Rezoning Transportation Analysis

Petition Number: 2021-081

Date	Description
08-02-2021	First Review (KP)

PROJECT NO.:	MRE-13040
FILENAME:	
DESIGNED BY:	BGP
DRAWN BY:	BGP
SCALE:	
DATE:	12-15-2017
SHEET NO.:	RZ-1

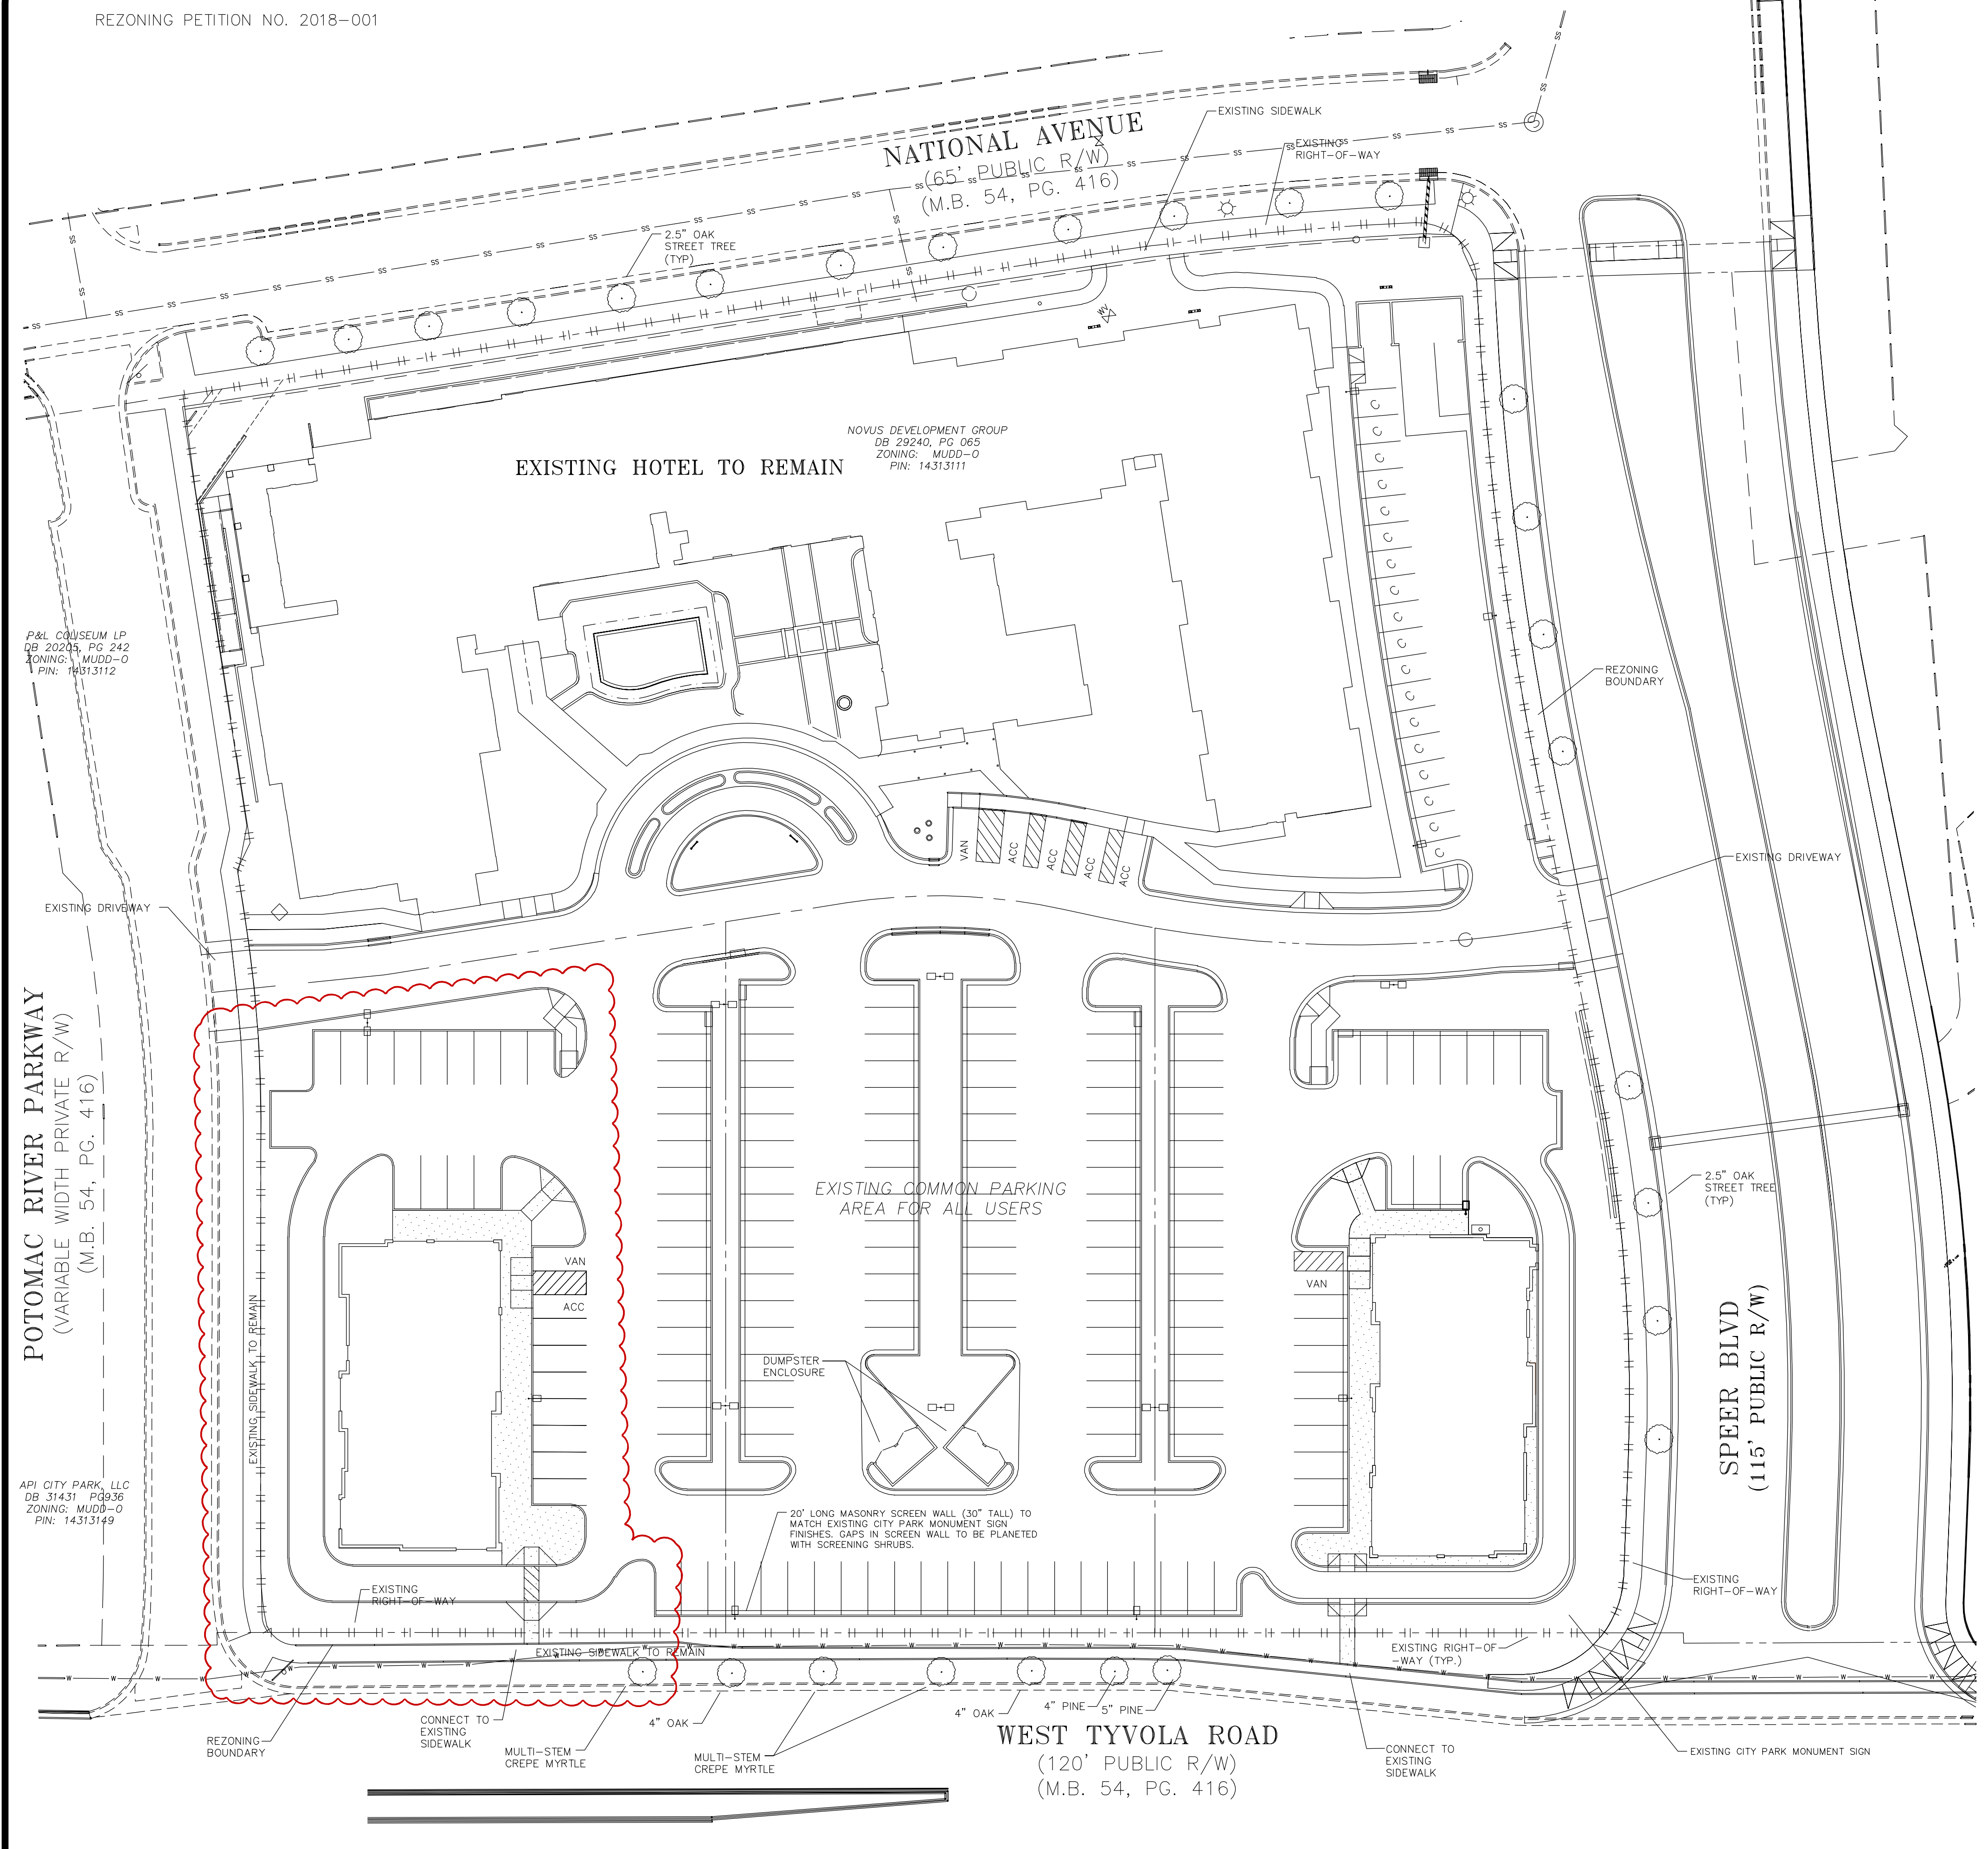
- Revise rezoning sheet RZ-1 to accurately reflect the existing striping on Speer Boulevard and removing the traffic signal at the intersection of Speer Boulevard and Tyvola Road.

PROJECT NO. MRE-13040  
 FILENAME: MRE13040-S1  
 DESIGNED BY: BGP  
 DRAWN BY: BGP  
 SCALE: 1" = 30'  
 DATE: 12-15-2017  
 SHEET NO. **RZ-2**

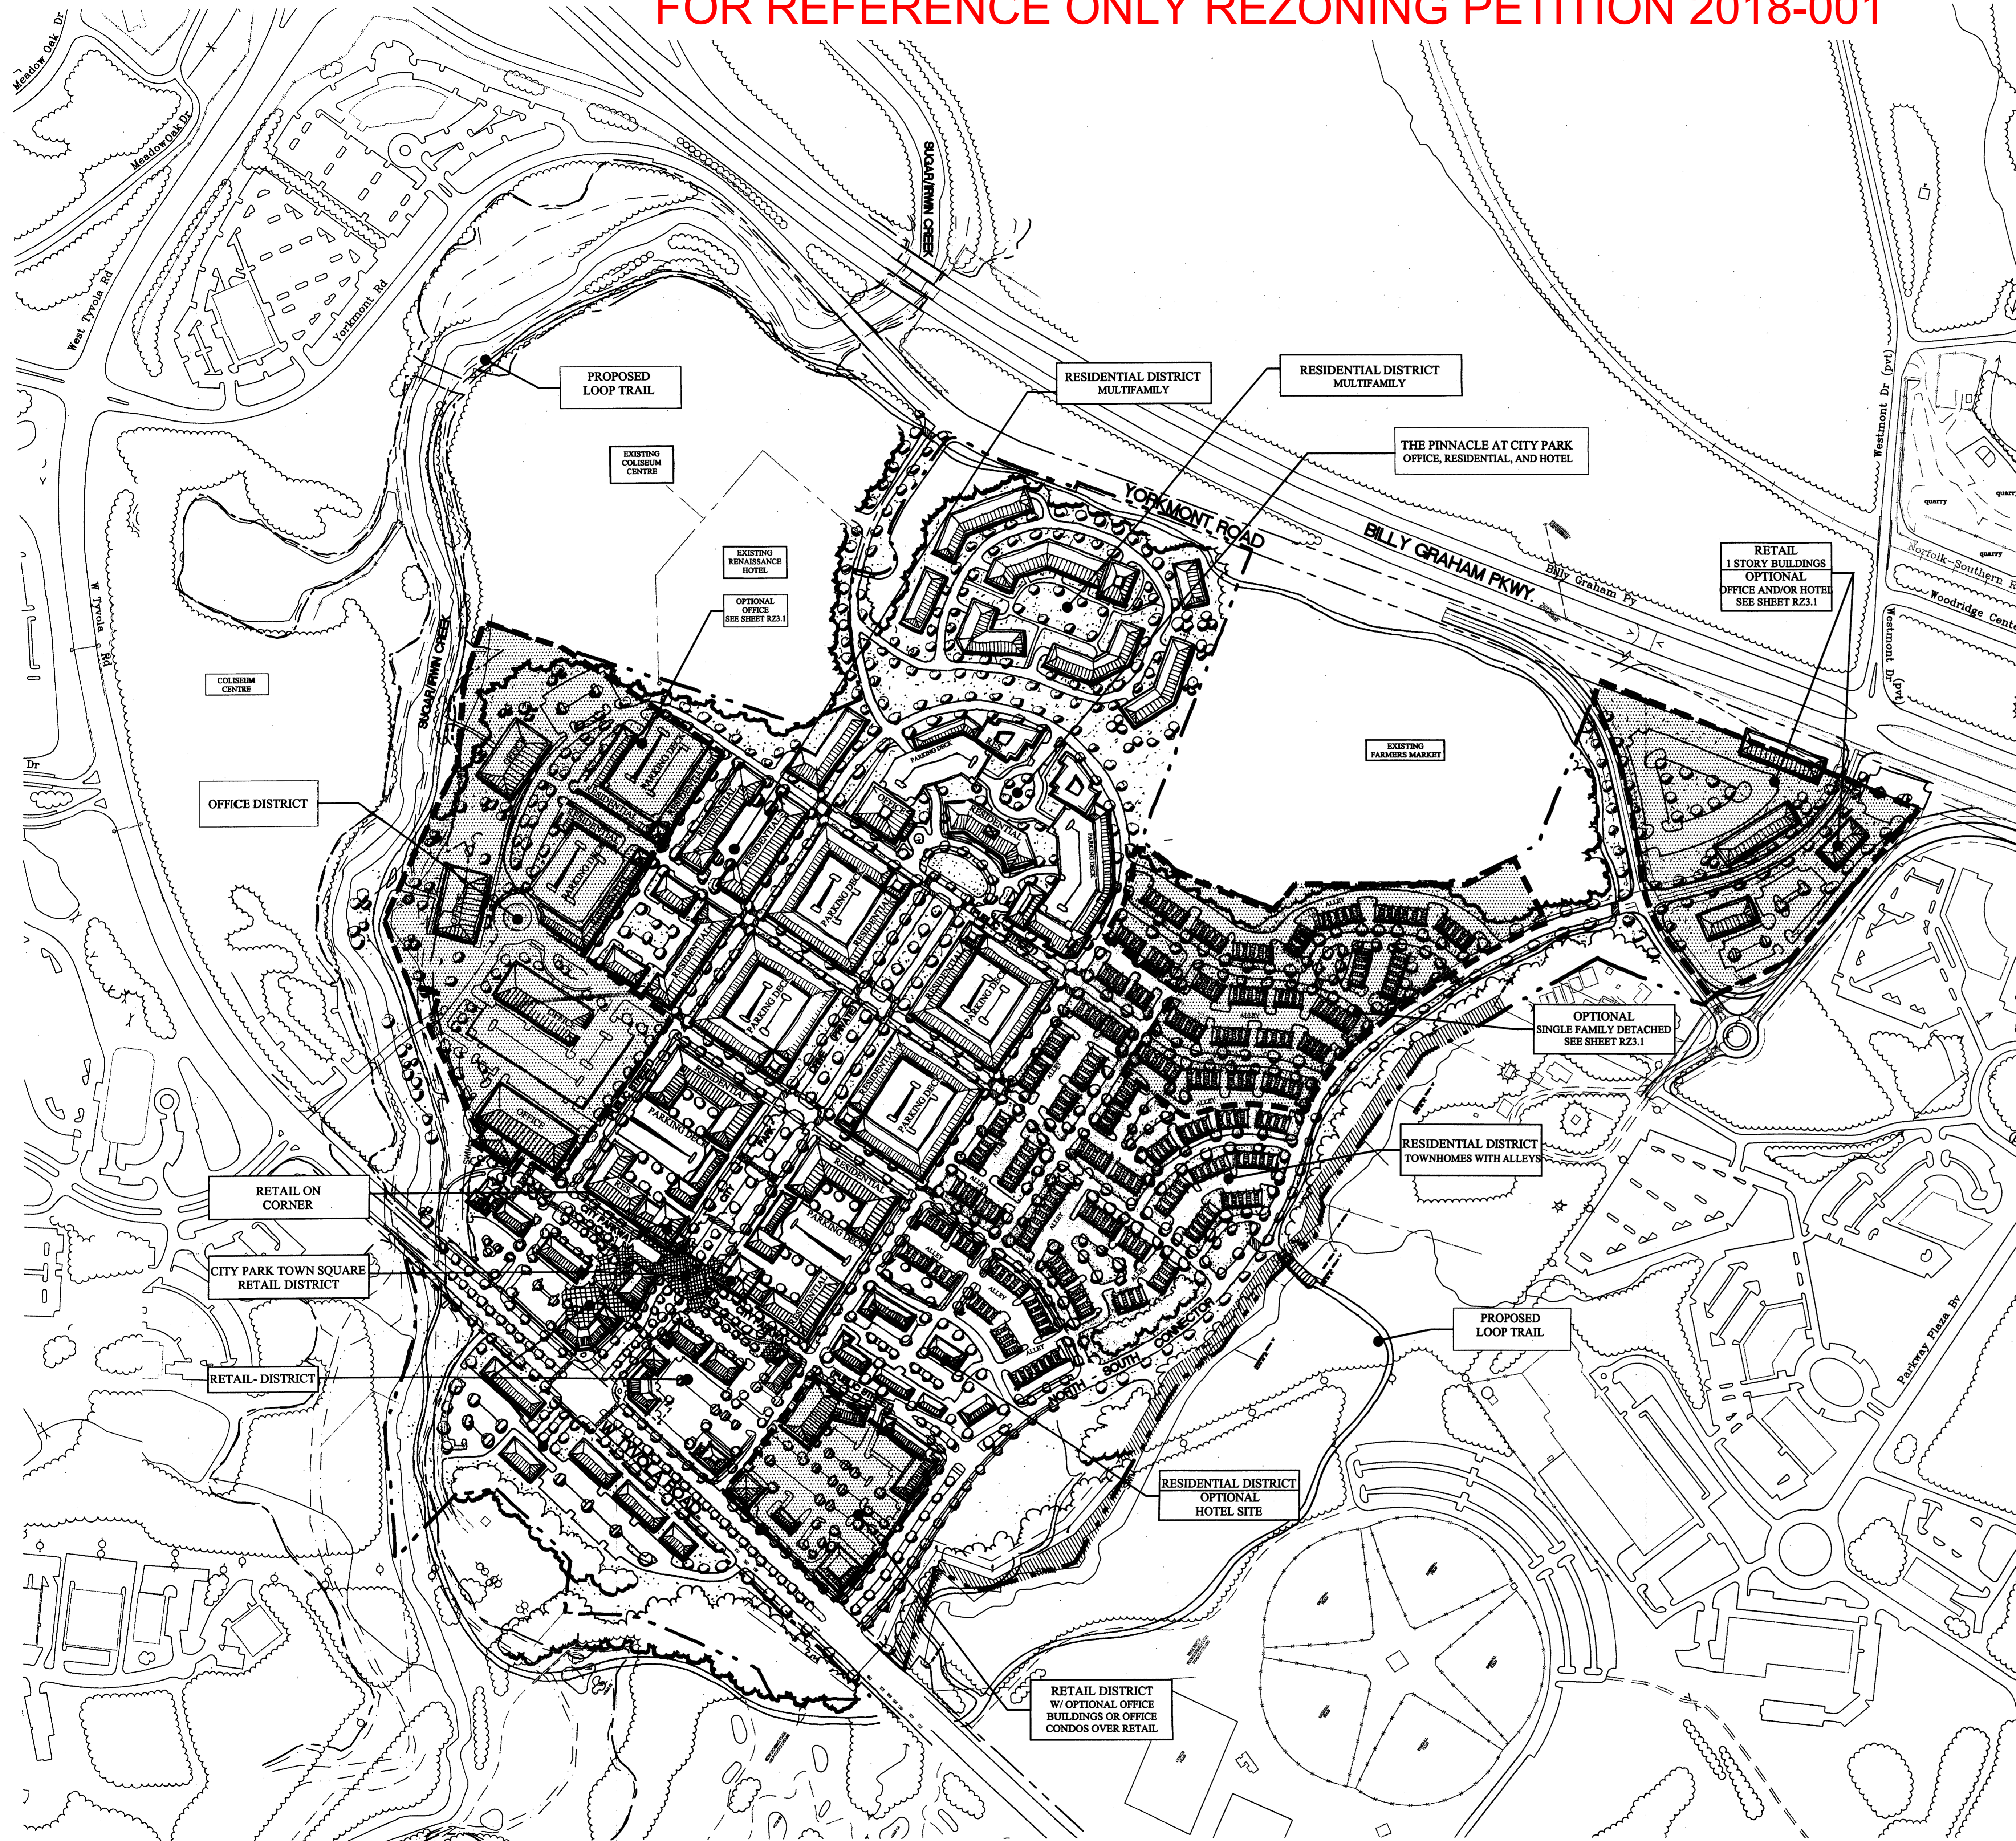
- Revise rezoning sheet RZ-2 by completing, and including, the following tracking table for the transportation improvements established in the original 2007-082 rezoning. Pending the table's completion and CDOT's review, CDOT may require any incomplete transportation improvement(s) to be included as a part of this petition and completed upon development of this site.
